## Application by Photovolt Development Partners on behalf of Solar Five Limited (the Applicant) for an Order Granting Development Consent for the Botley West Solar Farm

**The Examining Authority's second written questions and requests for information (ExQ2): Issued on 30 July 2025**

Illustrative Masterplan
Figure 5.3A: Cable Corridor Option A

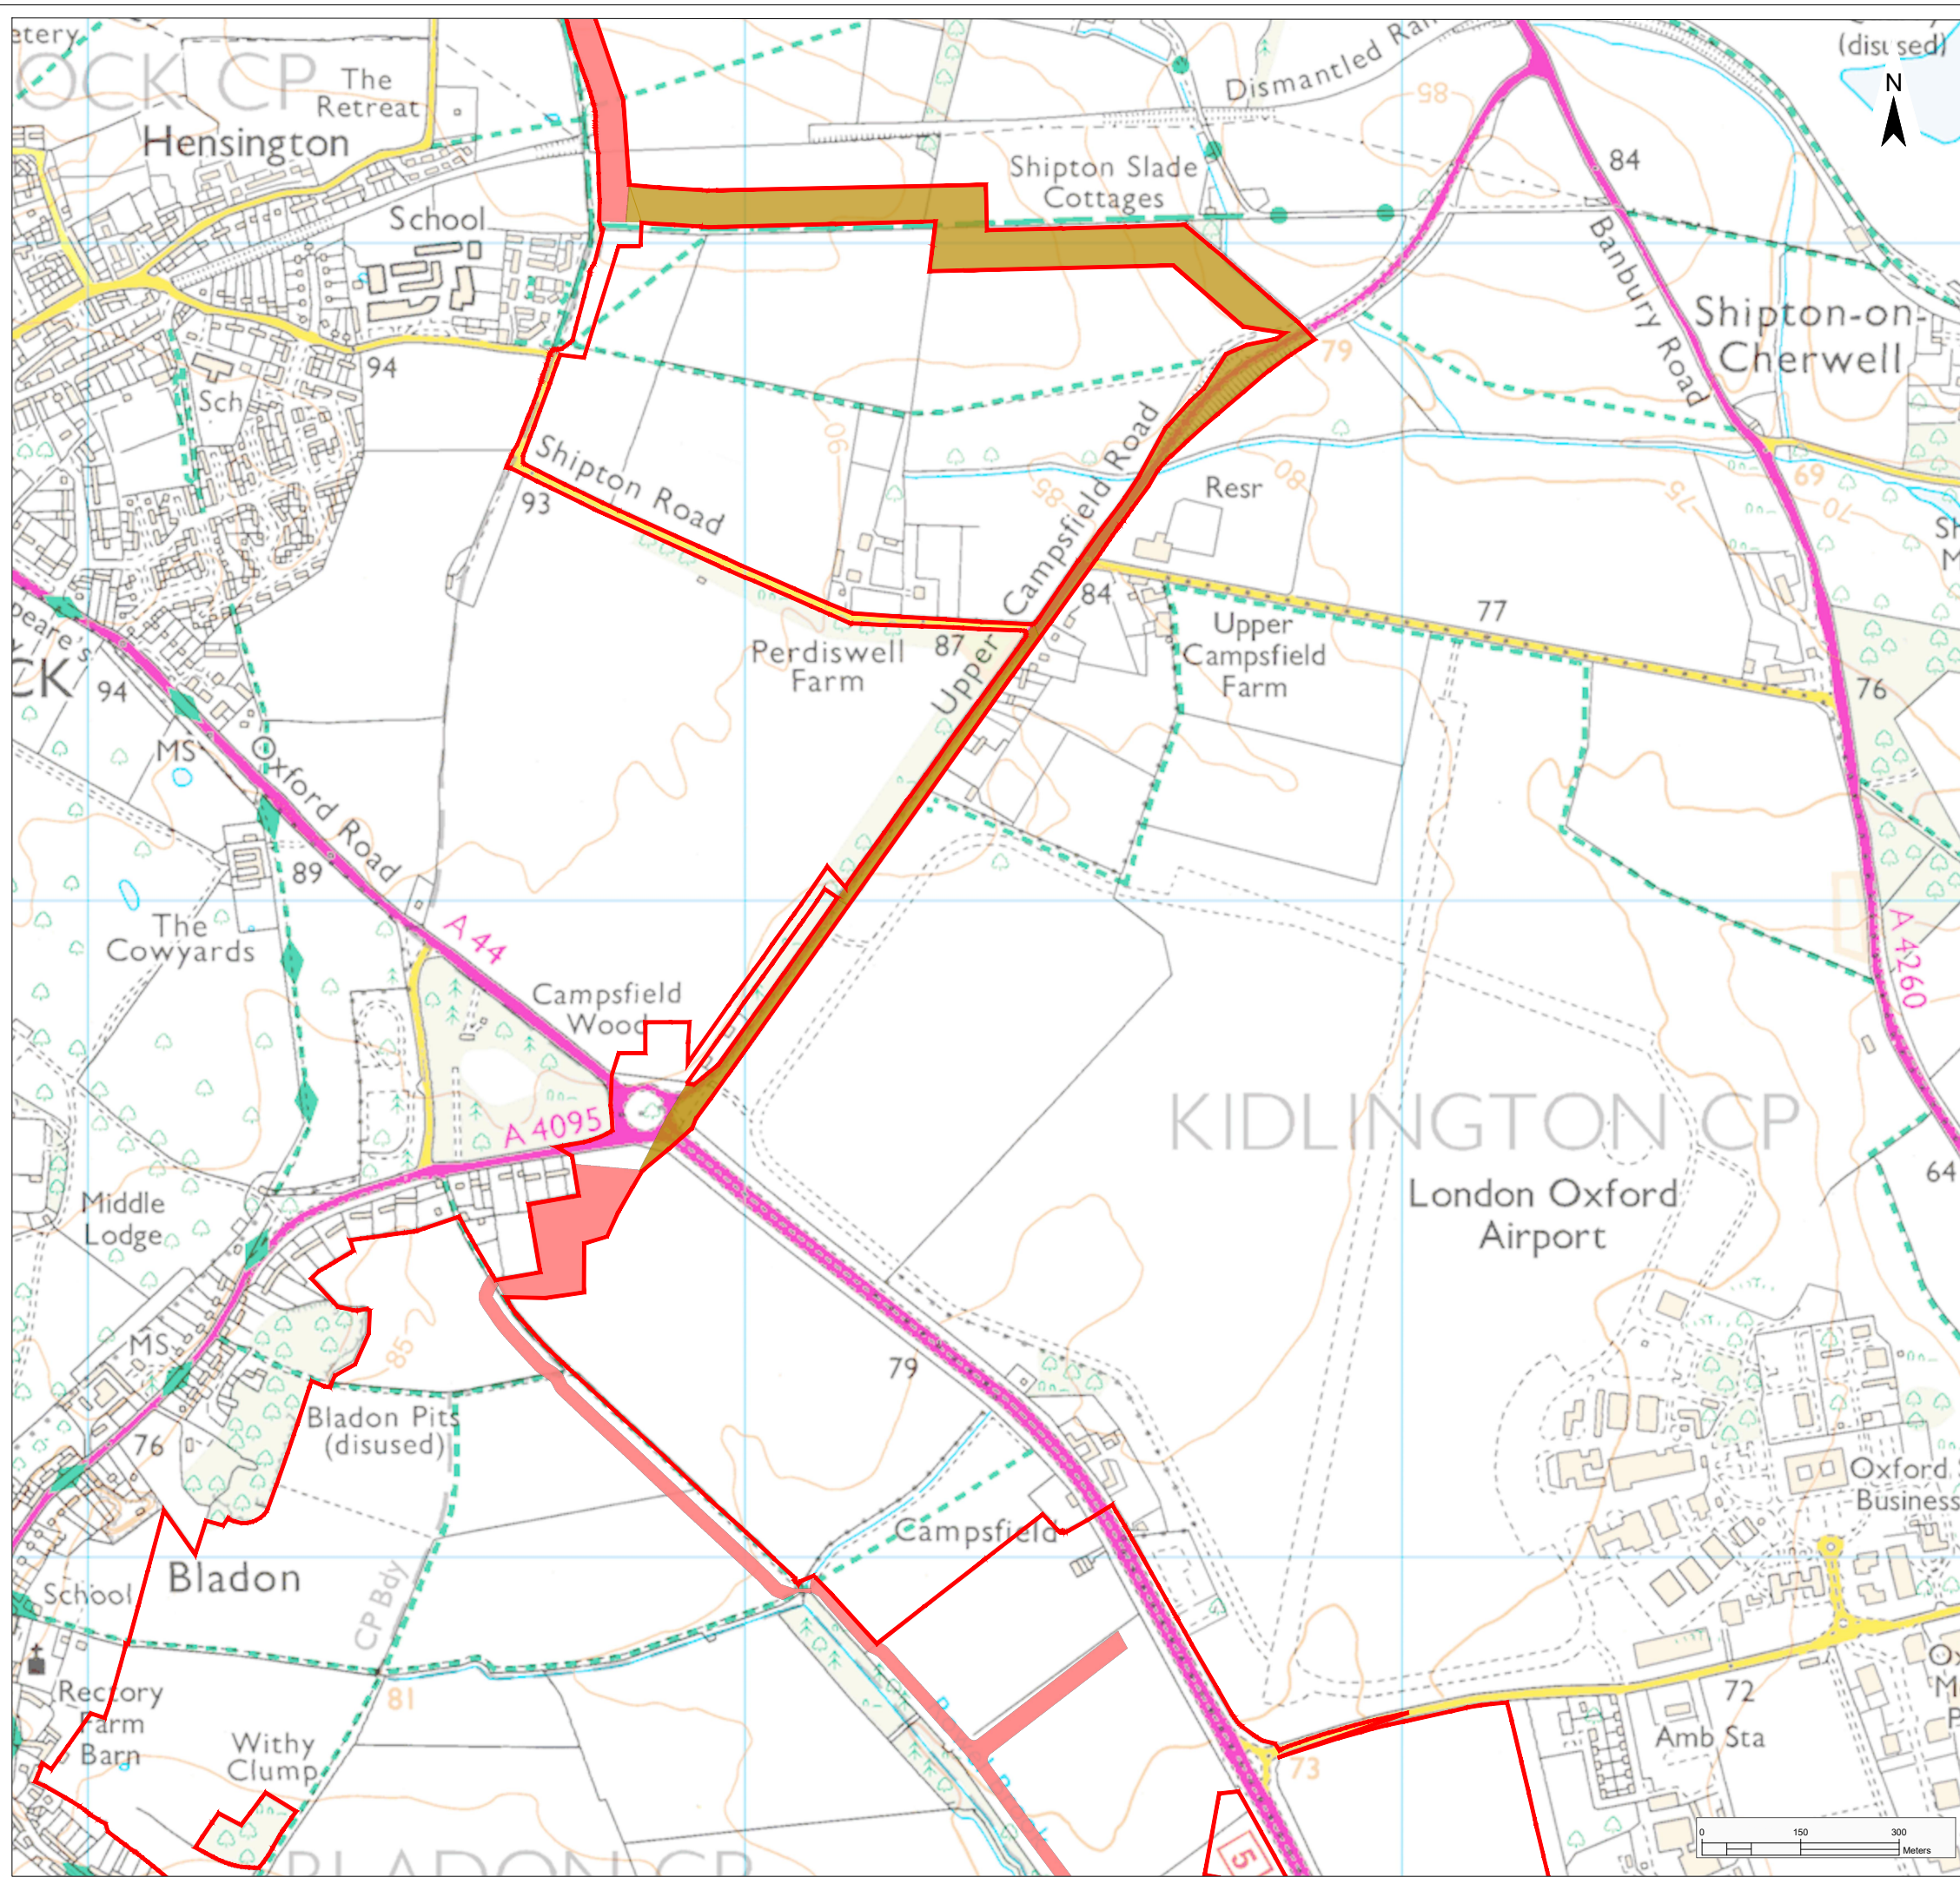
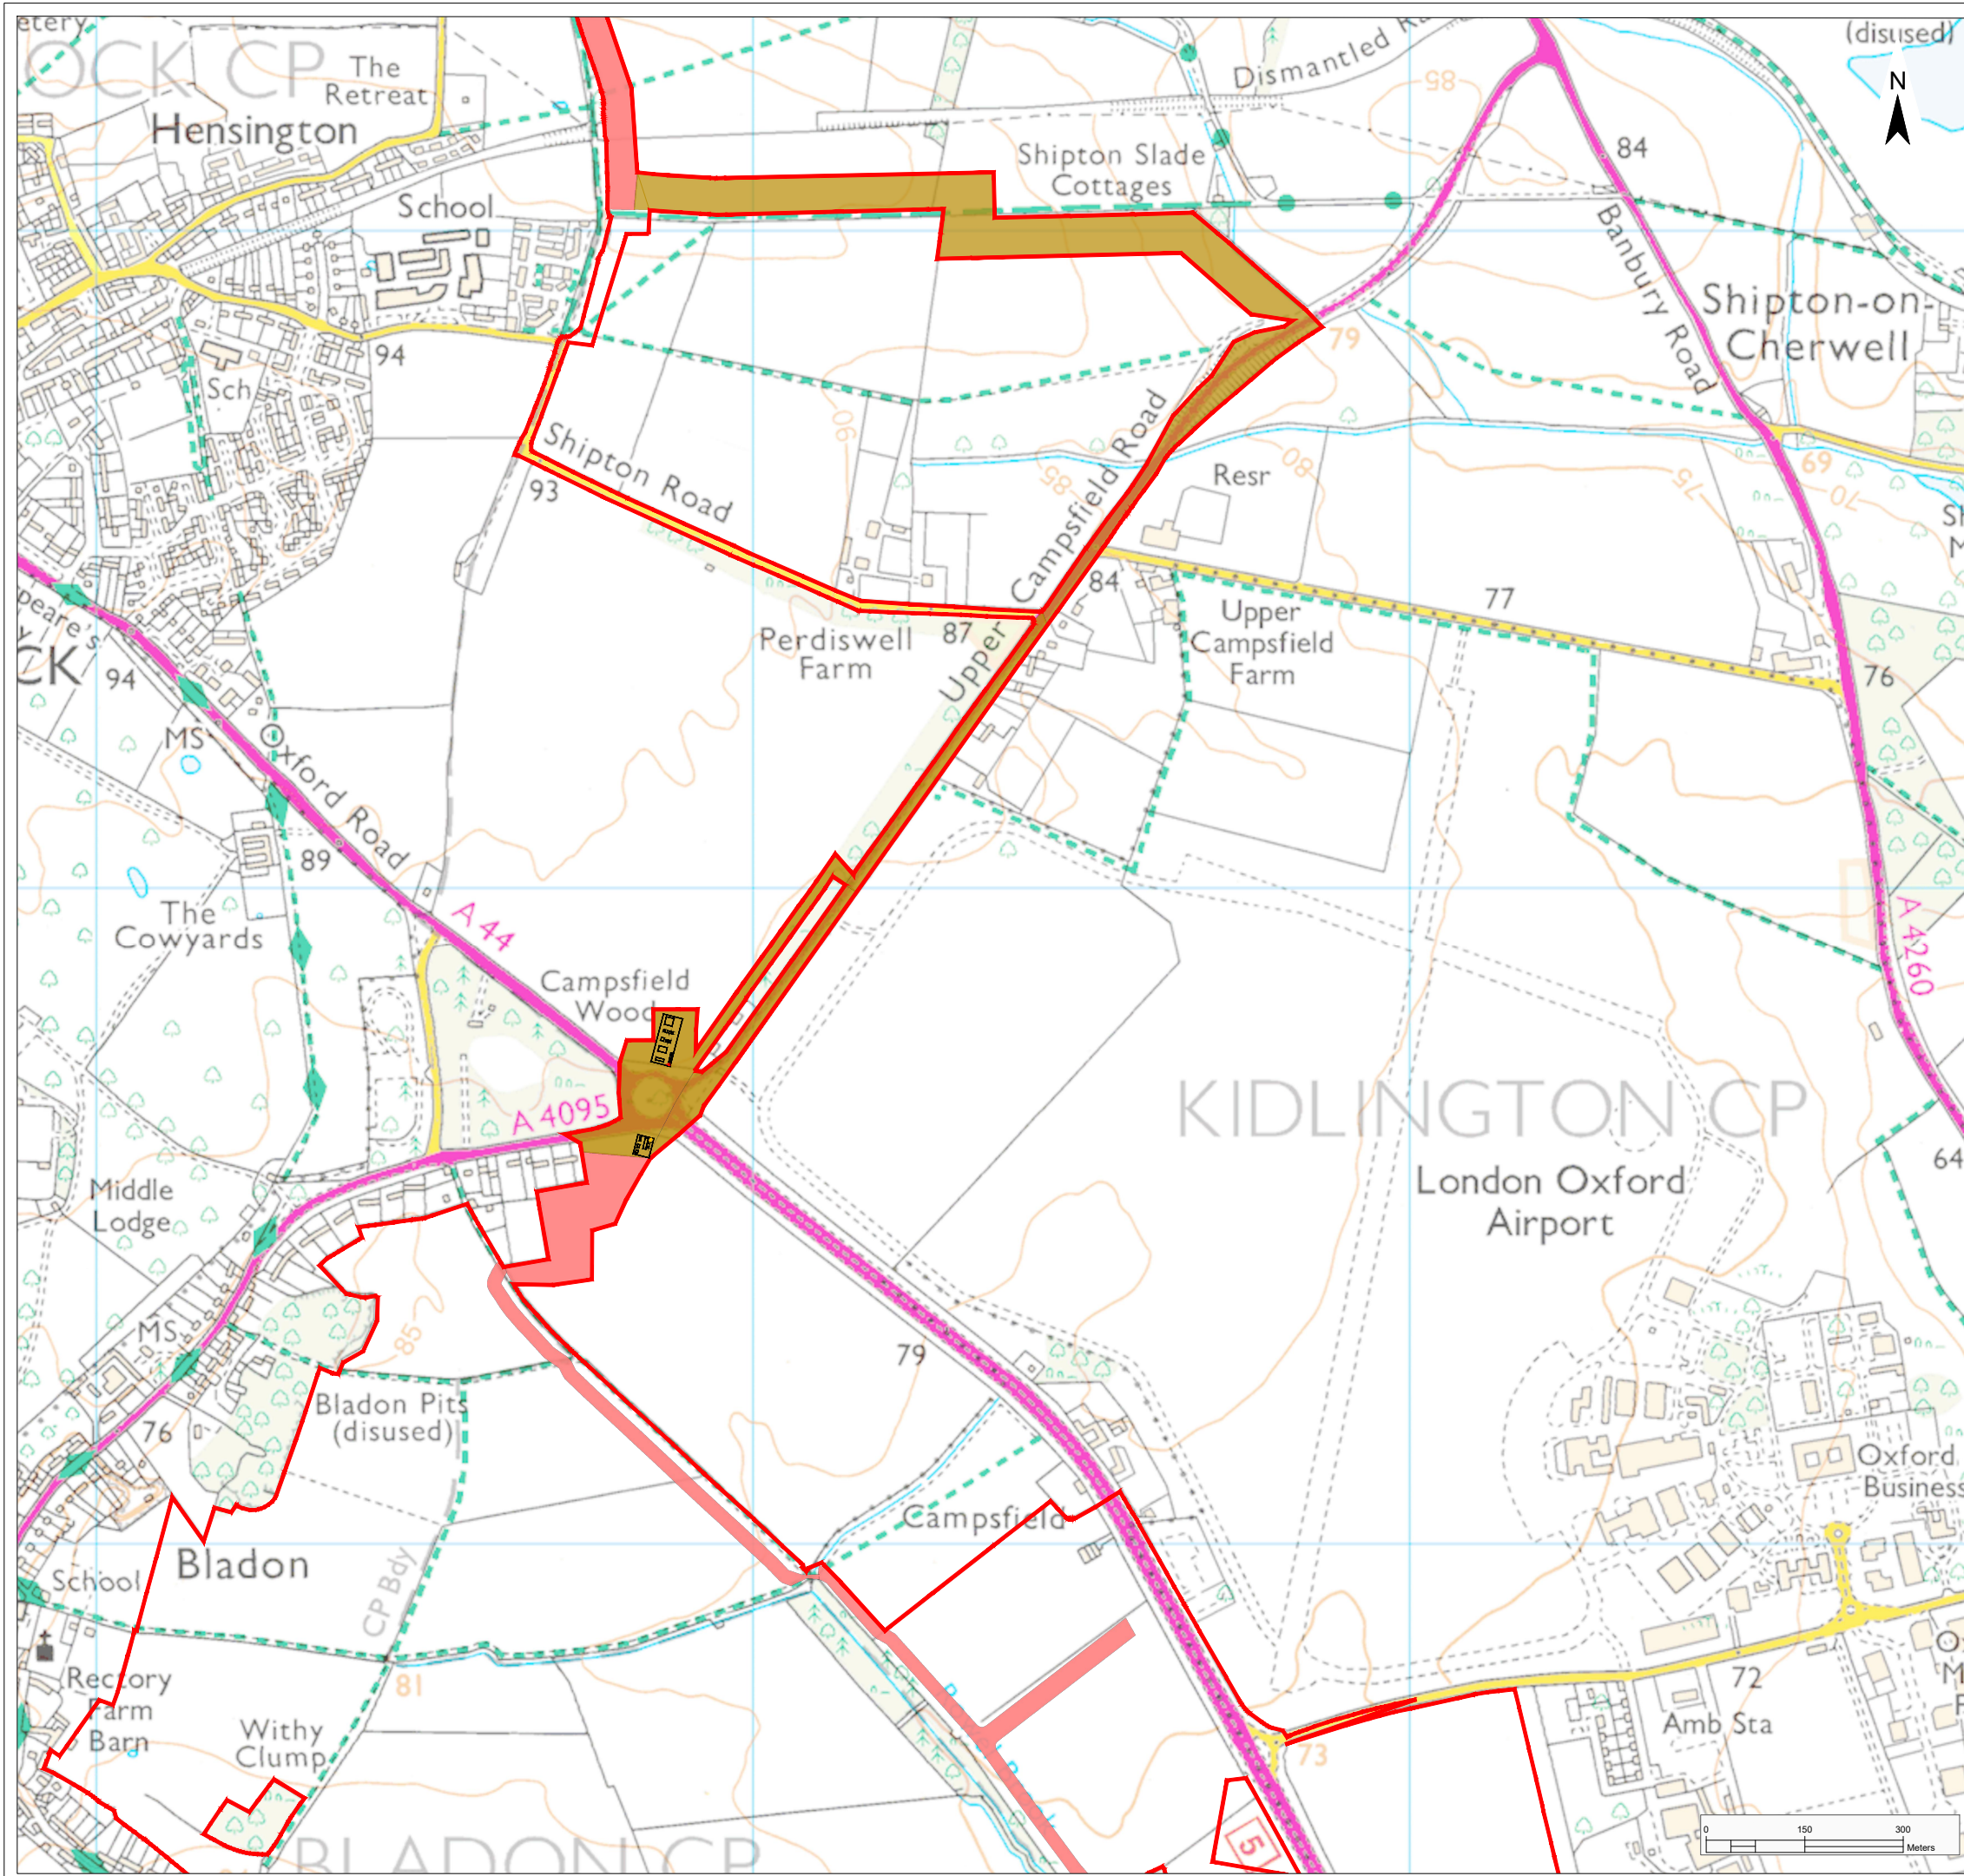
2.3.4	Applicant	<p><b>Cable corridor</b></p> <p>In response to ExQ1.3.10 [REP2-025], it is stated that any formal request to remove residual optionality (for the cable routing options) from the Order limits is unlikely until the outstanding surveys and agreements are concluded, which is expected in the post-consent phase. Explain:</p> <ol style="list-style-type: none"> <li>1) Who would be notified of the cable routeing decision outcomes and when.</li> <li>2) How would the discarded options be managed post-consent (i.e. for example is it just a case of not exercising Compulsory Acquisition powers)?</li> <li>3) Have any surveys or investigations to date indicated a potential preference in cable corridor routeing?</li> </ol> <p>Should the optionality, or at least the decisions in relation to the optionality, be subject of a Requirement that would secure a choice of cable routeing that subsequently prevents other options from also being pursued?</p>

2.3.8	Applicant	<p><b>Cable corridor</b></p> <p>In response to ExQ1.3.10 [REP2-025], it is stated that any formal request to remove residual optionality (for the cable routing options) from the Order limits is unlikely until the outstanding surveys and agreements are concluded, which is expected in the post-consent phase. Explain:</p> <ol style="list-style-type: none"> <li>1) Who would be notified of the cable routeing decision outcomes and when.</li> <li>2) How would the discarded options be managed post-consent (i.e. for example is it just a case of not exercising Compulsory Acquisition powers)?</li> <li>3) Have any surveys or investigations to date indicated a potential preference in cable corridor routeing?</li> </ol> <p>Should the optionality, or at least the decisions in relation to the optionality, be subject of a Requirement that would secure a choice of cable routeing that subsequently prevents other options from also being pursued?</p>
